**Re: Unser/McMahon Mixed Use 10715 Unser Blvd. NW
Erosion and Sediment Control Plan
Engineer's Stamp Date 04/12/2021 (A11E017)**

Based upon the information provided in your submittal received 4/13/2021, the above-referenced ESC Plan is approved to be included in the SWPPP and Work Order Plans with the following conditions.

ENGINEER'S SEAL	UNSER & McMAHON
		Unser Blvd & McMahon Blvd
		EROSION CONTROL PLAN
		SHEET #
		ECP-1
		JOB #
		2020015

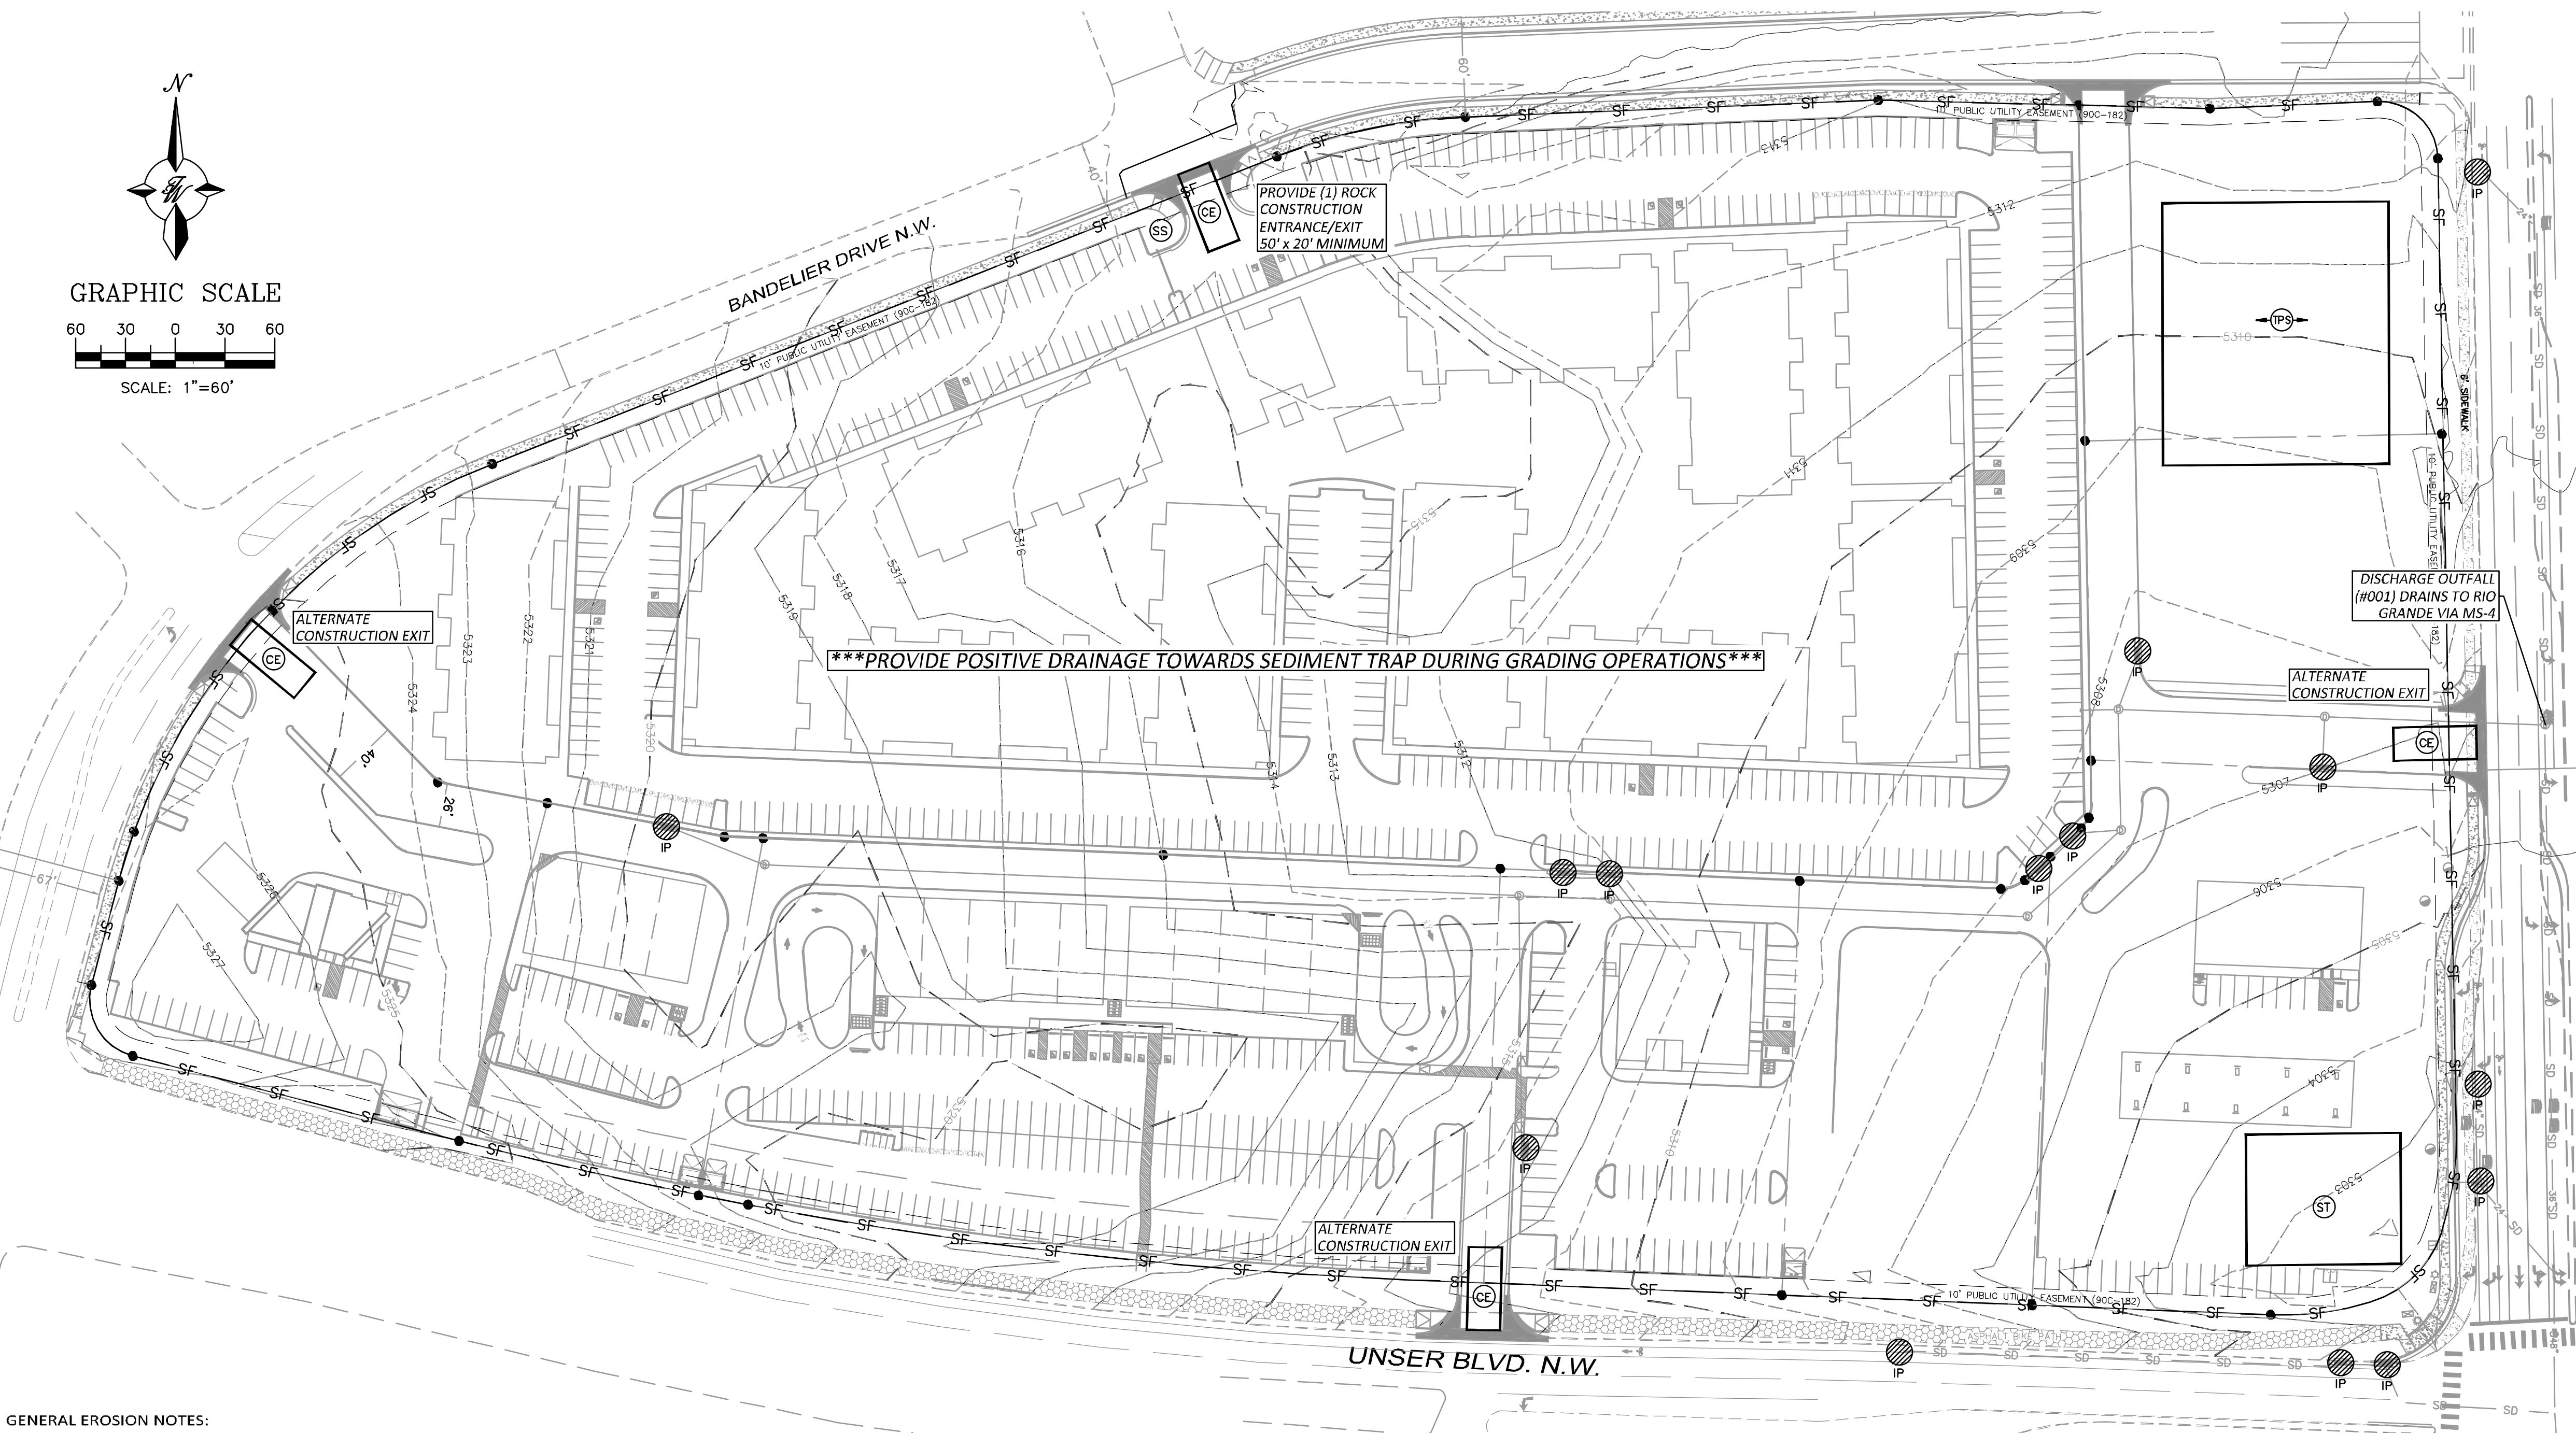
2. Two operators are known, the owner and the contractor. Presumably, they will be sharing one SWPPP. If so, Please update the operator information on the ESC plan and provide a copy.

3. Similarly, the SWPPP team is known by the contractor. Please update the team members on the ESC plan and provide a copy.
4. The distinction between temporary and final stabilization is unclear in the "Stabilization Measures" paragraph. There seems to be an inference that crimped straw, a temporary measure, would satisfy the final, Arid exception, criteria. Later in that paragraph, the critical word "and" is omitted from the attempted quote of the Arid Exception, CGP 2.2.14.b.iii. The term "and" joins the seeding portion of the criteria with the "non-vegetative erosion control" portion. The word "and" makes it clear that both are required. So please correct this paragraph and provide an updated copy of the plan.

5. The EPA identifies several methods of temporary stabilization in CGP 2.2.14.a and allows Reductions In Inspection Frequency for Stabilized areas in CGP 4.4.1. Please delete the paragraph titled Annual inspections from the plan and replace it with the minimum requirements of the CGP.

6. Add silt fence along the new roads after the infrastructure phase and throughout the sales phase to keep sediment out of the streets and storm drains.
7. Please keep the SWPPP up-to-date by identifying transfers as they occur.
